Application number: 2021/92462	
What is the application for?:	Outline application for erection of detached dwelling
Address of the site or building:	rear of, 1091, Manchester Road, Linthwaite, Huddersfield, HD7 5LS
Postcode:	HD1 4QT

Type of comment: An objection	
Do you wish your comments to be published on the website anonymously?	Yes
Objection to planning application 2021/92462 Land to rear of 1091 Manchester Road, Linthwaite, Huddersfield HD7 5LS The heritage statement attached as part of the planning application is incorrect and highly subjective as it only indicates one photographed aspect of properties adjoining the plot in question and fails to acknowledge the extent of the grade 2 listed zone in which this development would sit. Firstly the proposed development is a 2 bedroomed build and not a 3 bedroomed one as stated in this assessment. Referring only to the properties in the photograph, It argues “ Whilst the buildings are of a grade 2 listed status, it is not immediately clear from an initial look” and then “The rest of the buildings structure though is authentic and uses hammer dressed stone with stone brackets to guttering and stone slate roof.” This is a biased argu

STATUS			PROVISIONAL		
PROJECT			LAND OFF 1091 MANCHESTER ROAD		
TITLE			PROPOSED		
CLIENT			P.WHITING		
DRAWN BY	CHECKED BY	DATE			
Author	Checker	12.05.2021			
SCALE (@ A1)		PROJECT NUMBER			
As indicated		HD.20.33			
DRAWING NUMBER				REV	
HD.20.33.01

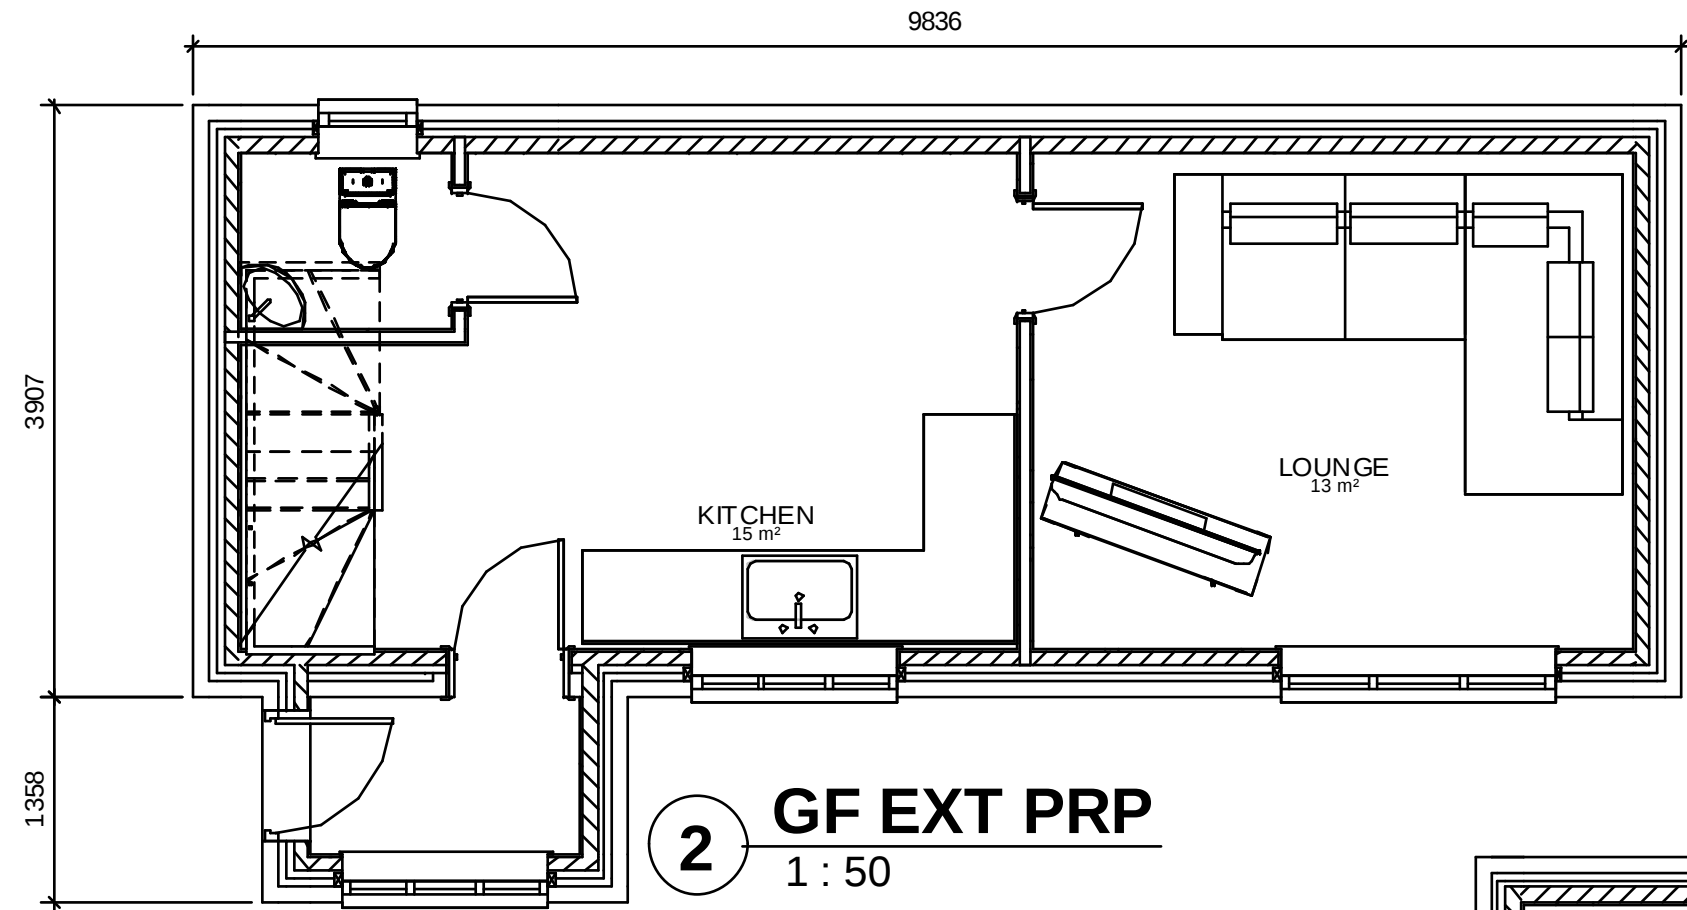
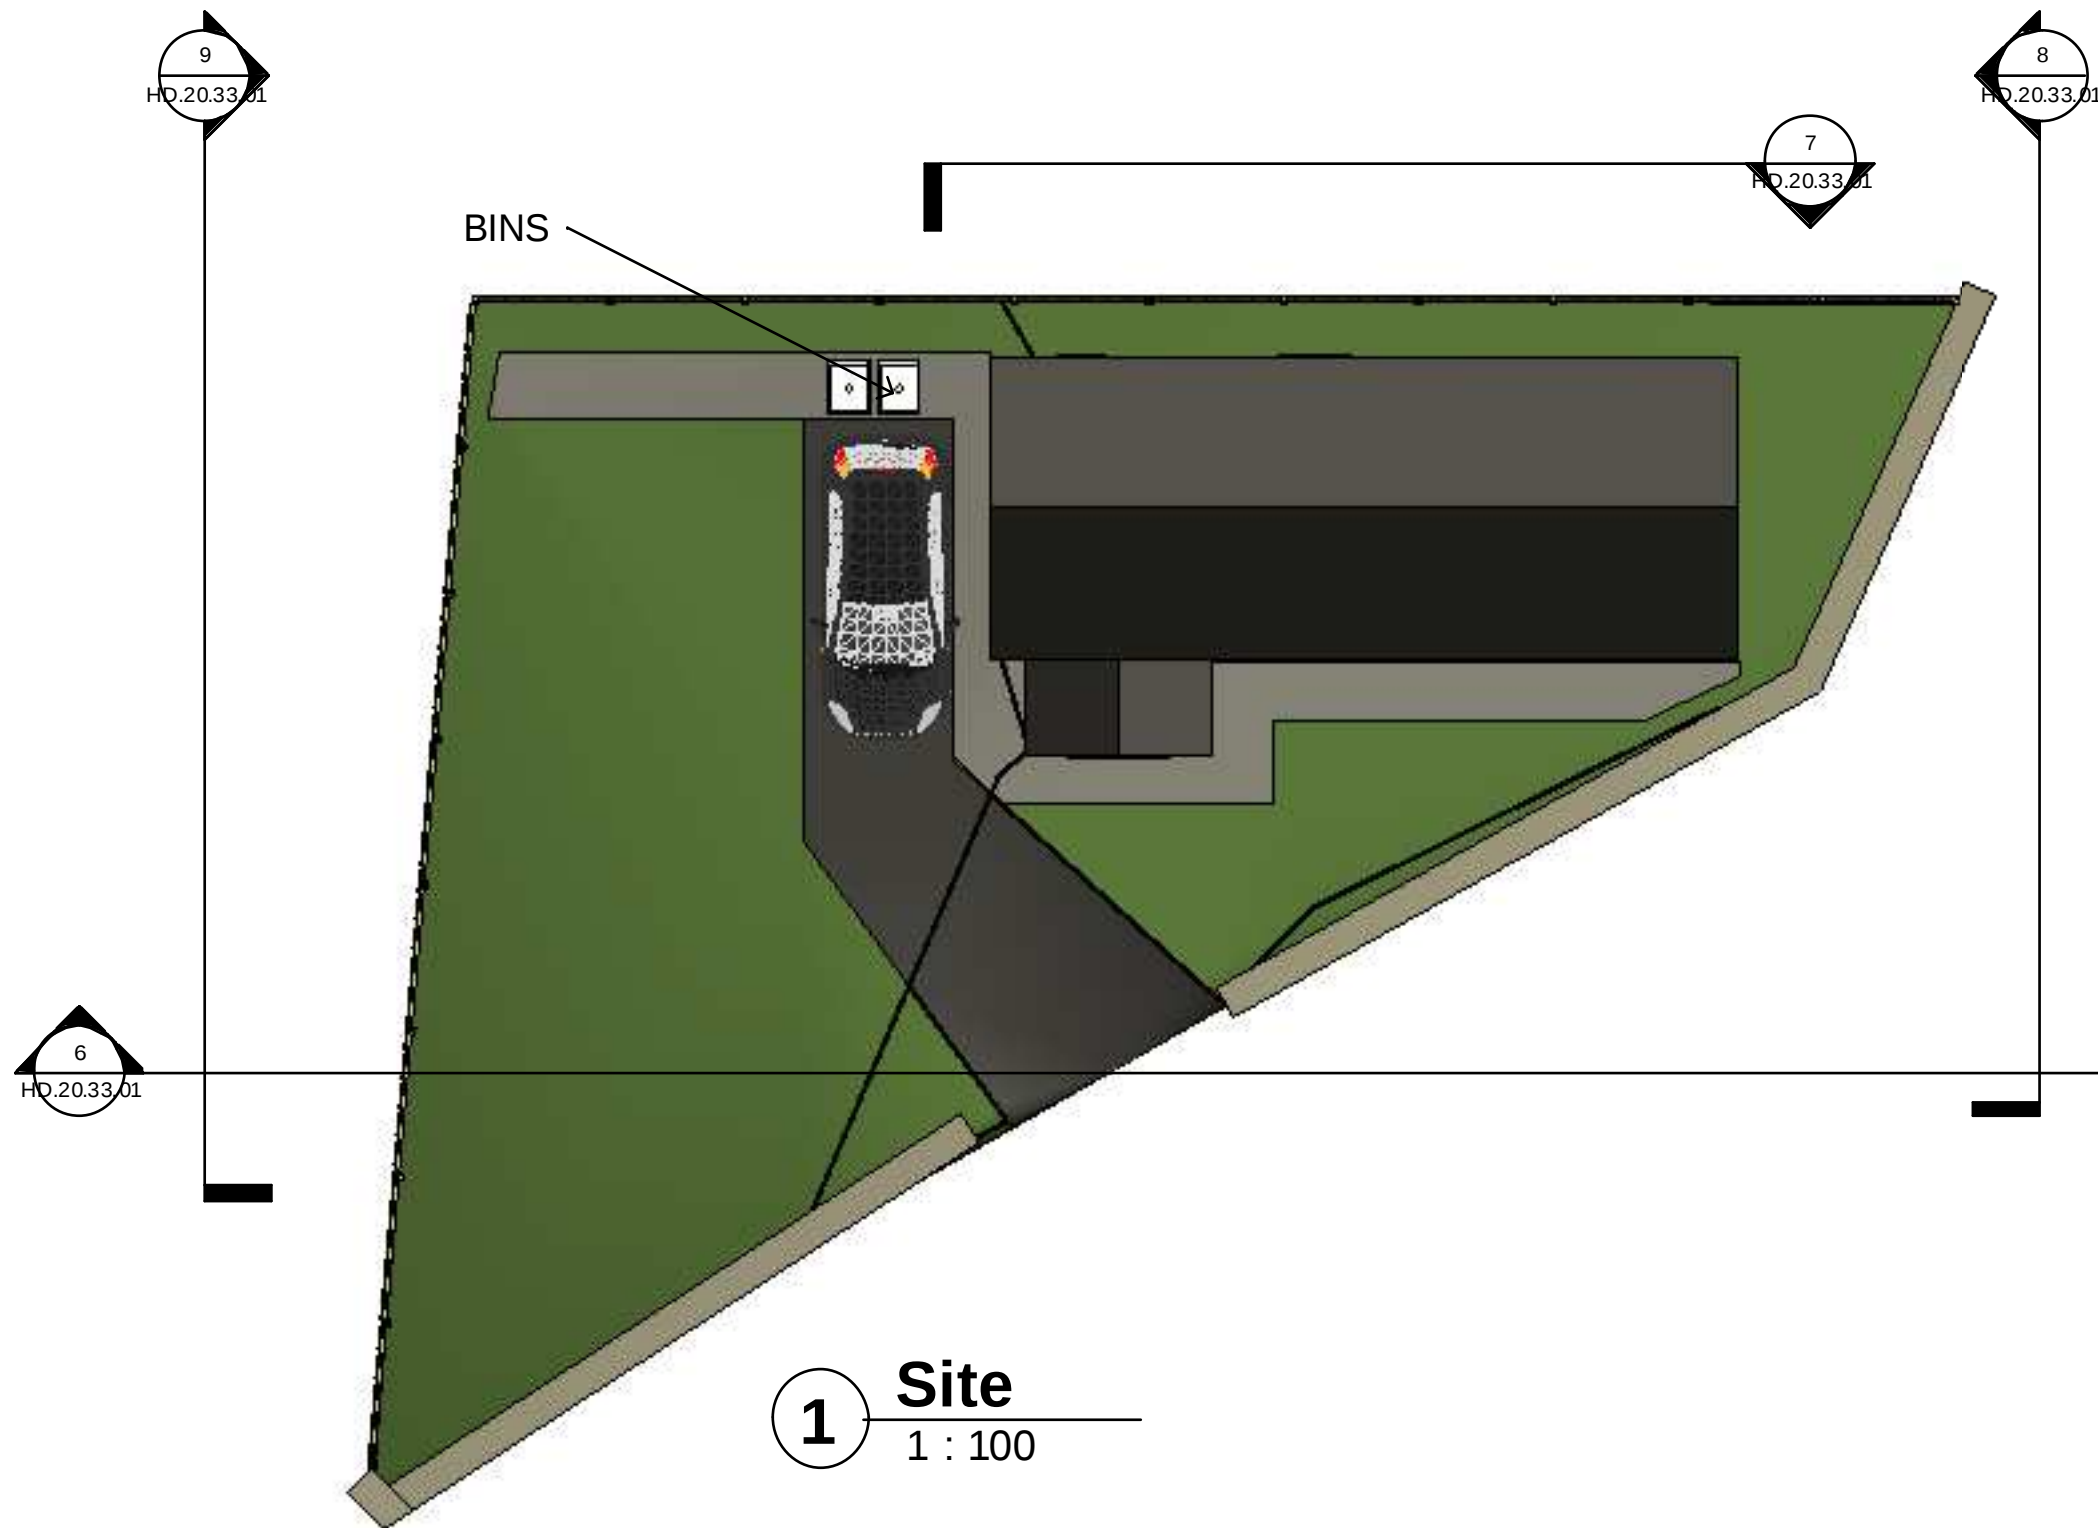
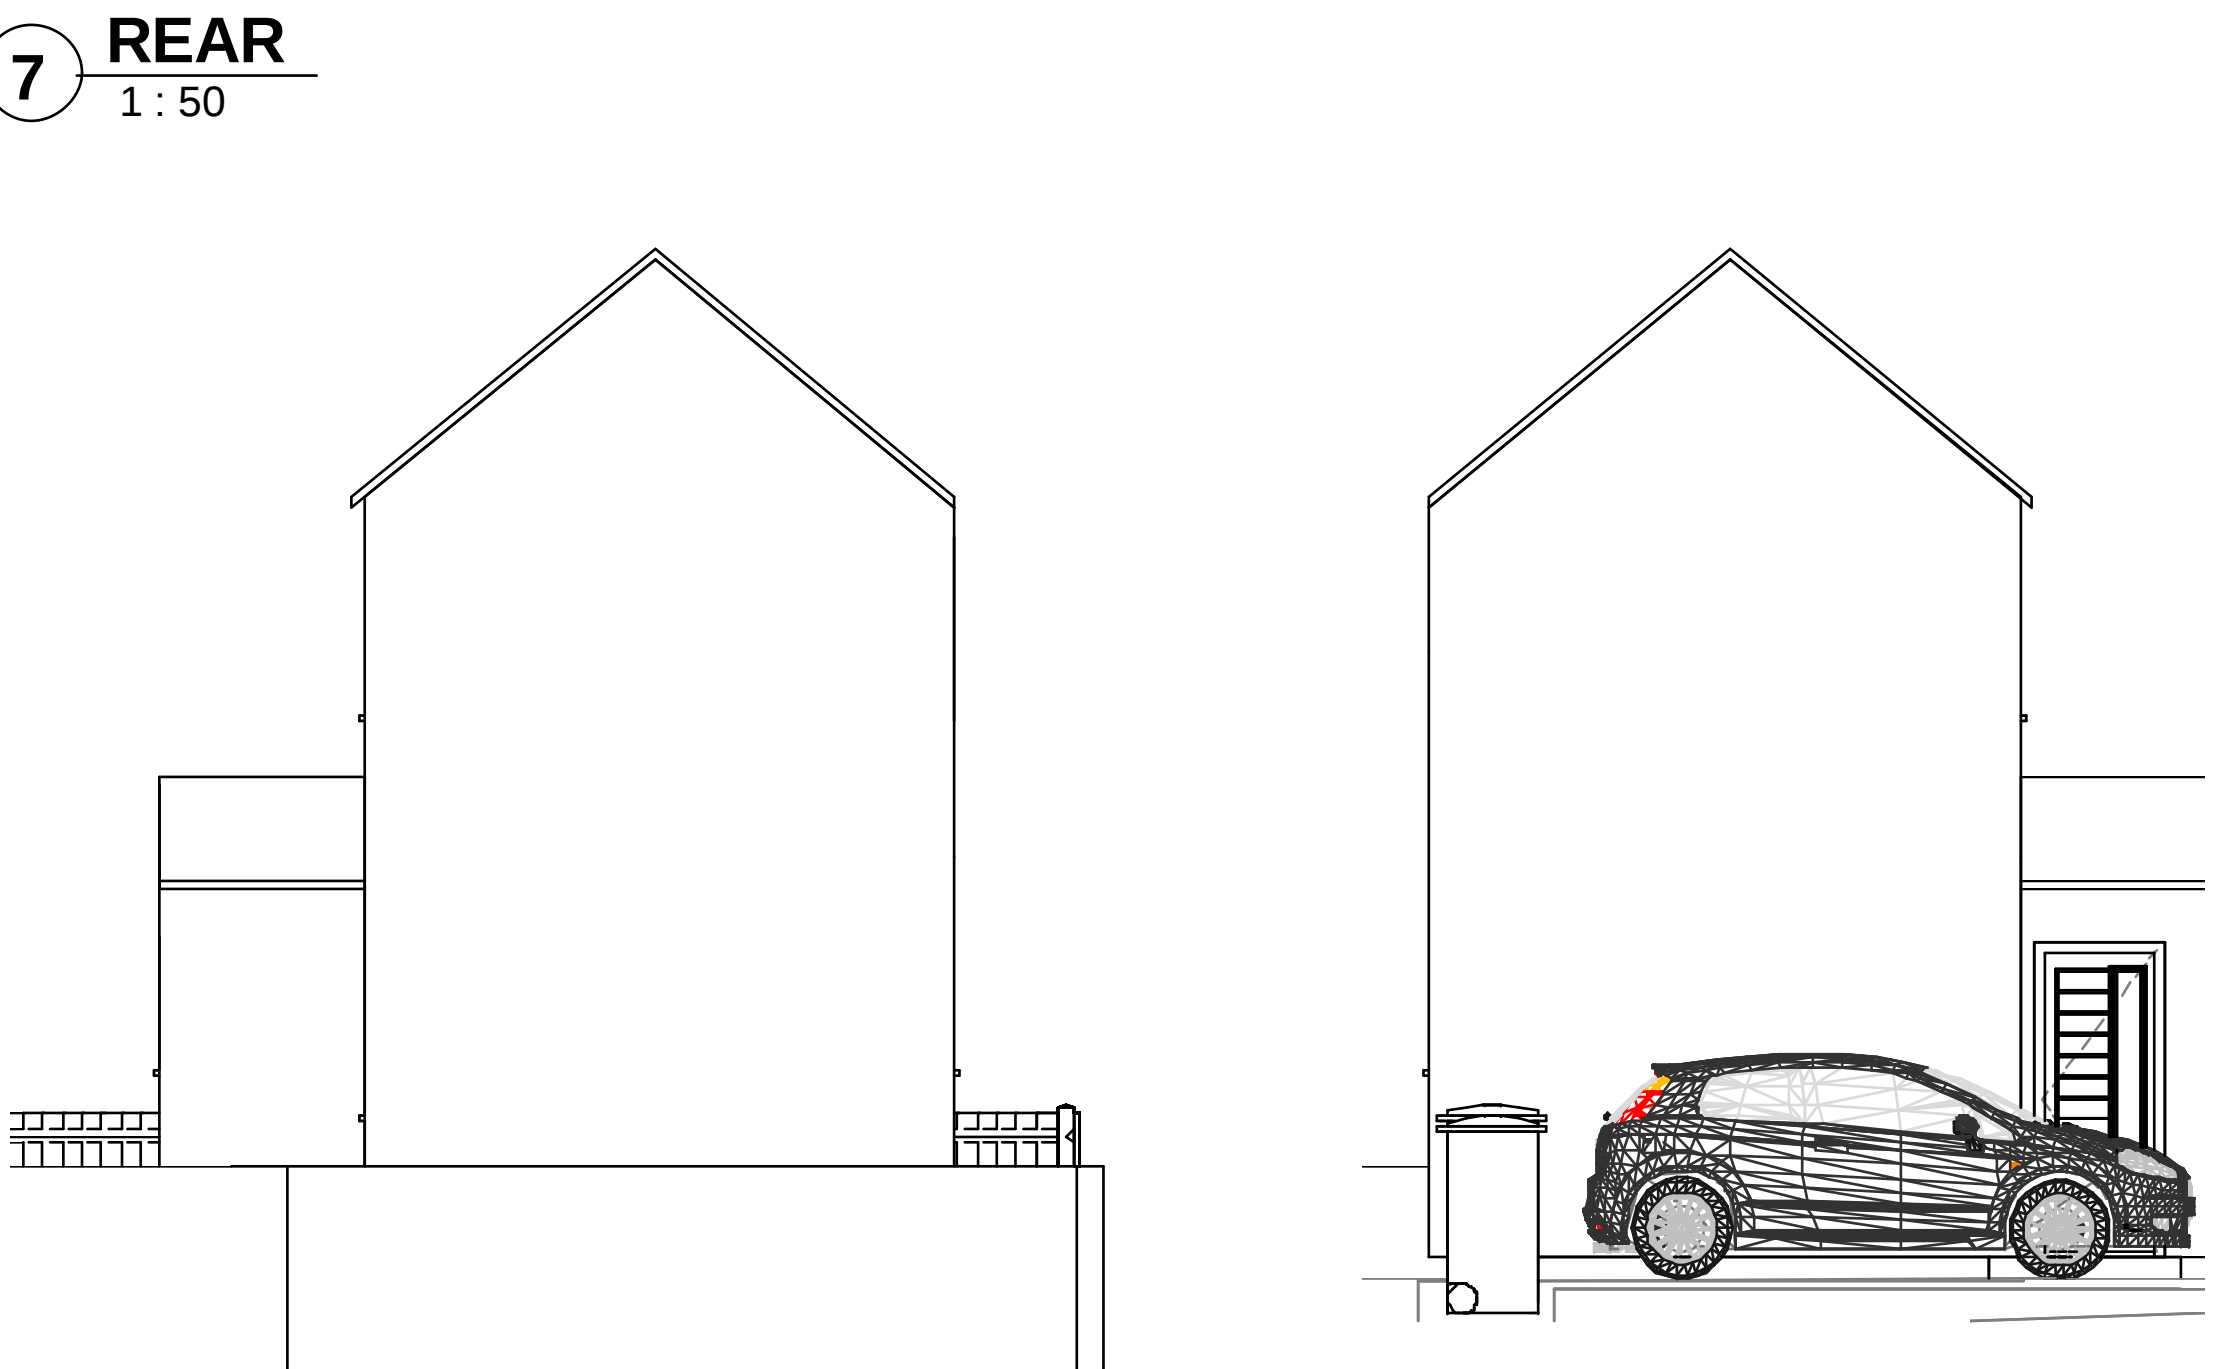
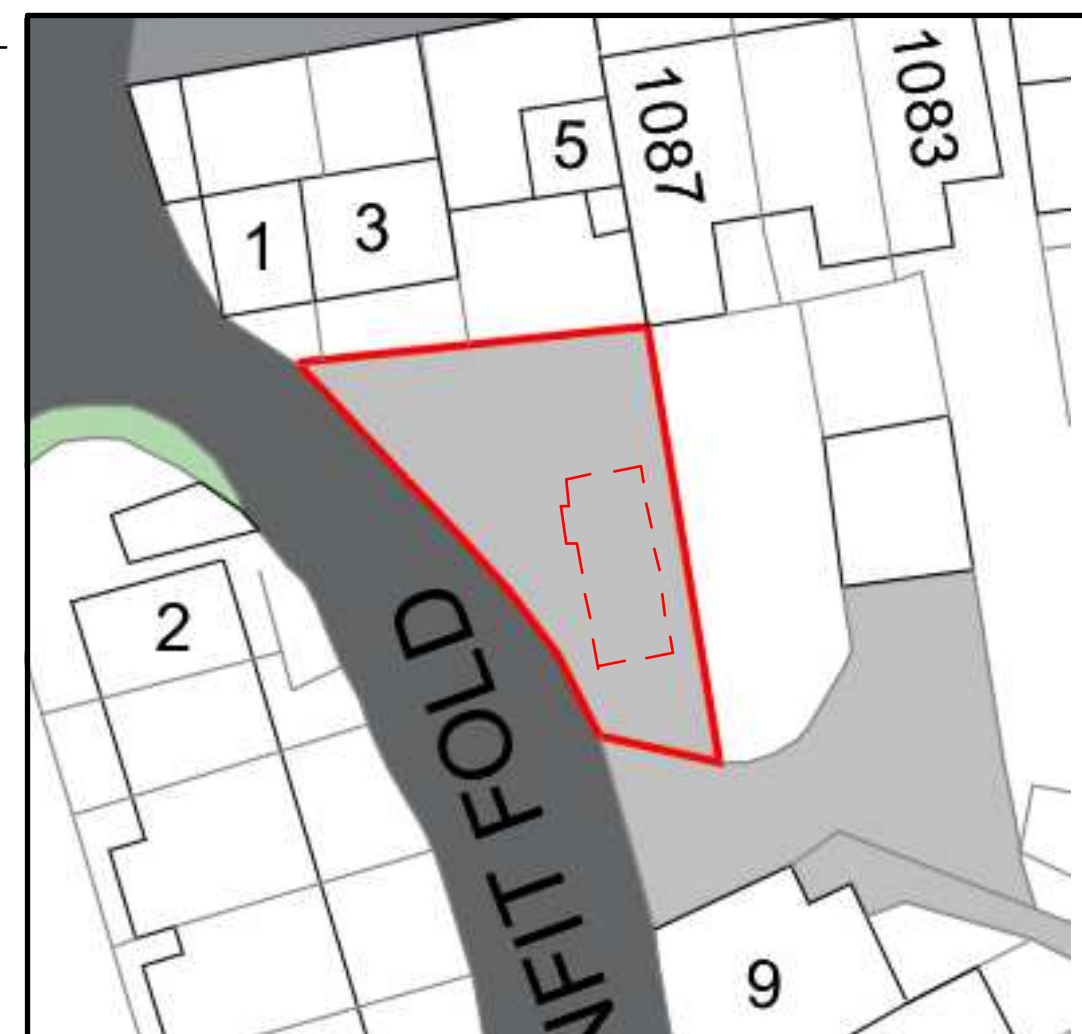
Albeit that it is suggested to use stone and slate in the new build, the actual placements of the windows in the proposed build do not reflect the weavers cottage style of its surroundings.

Furthermore on a practical level, the proposed one way driveway to the property would be a hazard for entering / exiting due to sight-lines and the amount of traffic using Linfit Fold to access the numerous properties on Bank Road and other housing estates.

three of the properties
on Manchester Road to which the plot adjoins. All of these properties will be greatly
affected by a lack of light and I am confident they would
object to the development on that basis.
